Your Ref: 2021/93644
Our Ref: X018665

29th October 2021

Low Farm, Wakefield Road, Flockton, Huddersfield – Erection and operation of grid-connected solar photovoltaic farm, with ancillary infrastructure and landscaping and biodiversity enhancements

# LOW FARM CABLE ROUTE TO POC

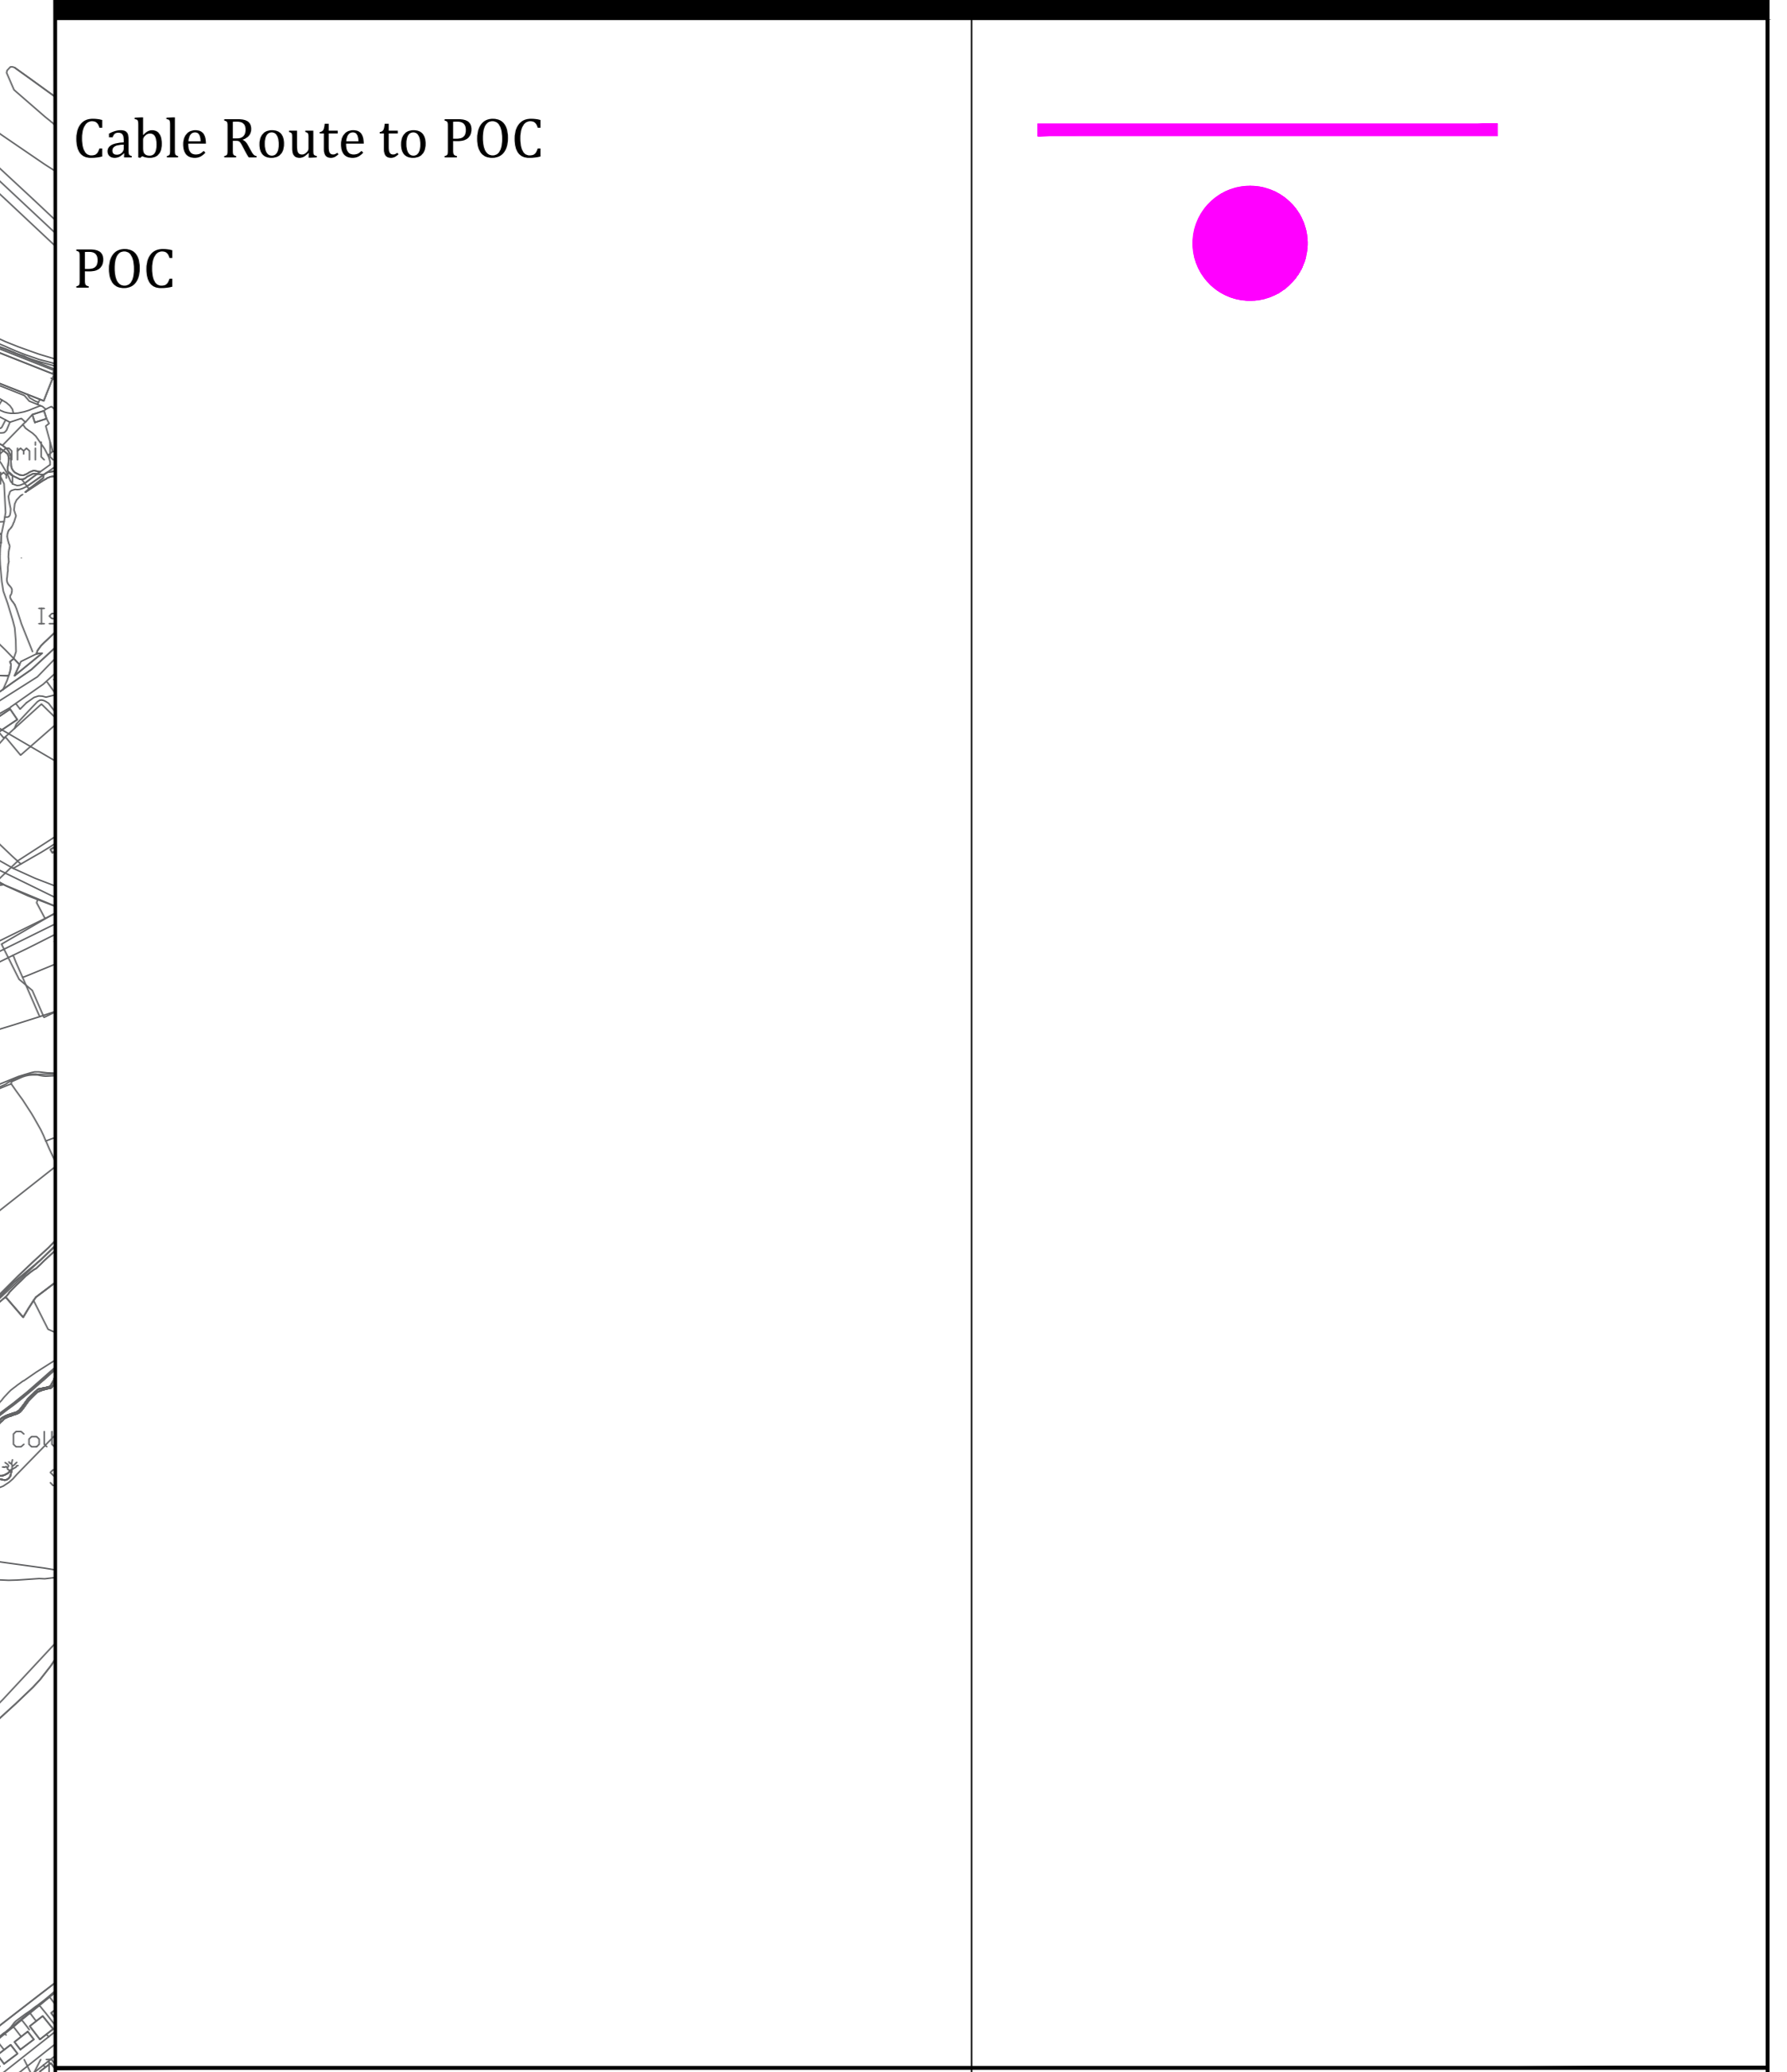
2) From the submitted plans, c. 3km of cable to be laid within Wakefield Road to the point where it connects to the grid. No 'critical' sewers are within the road, with the largest being a 300 mm diameter combined sewer close to the point of connection to the grid. The construction and laying of the cable will be controlled via the 'New Roads and Street Works Act (NRASWA)', although we do recommend that care is taken in respect of the public Yorkshire Water infrastructure present (sewers & water mains).
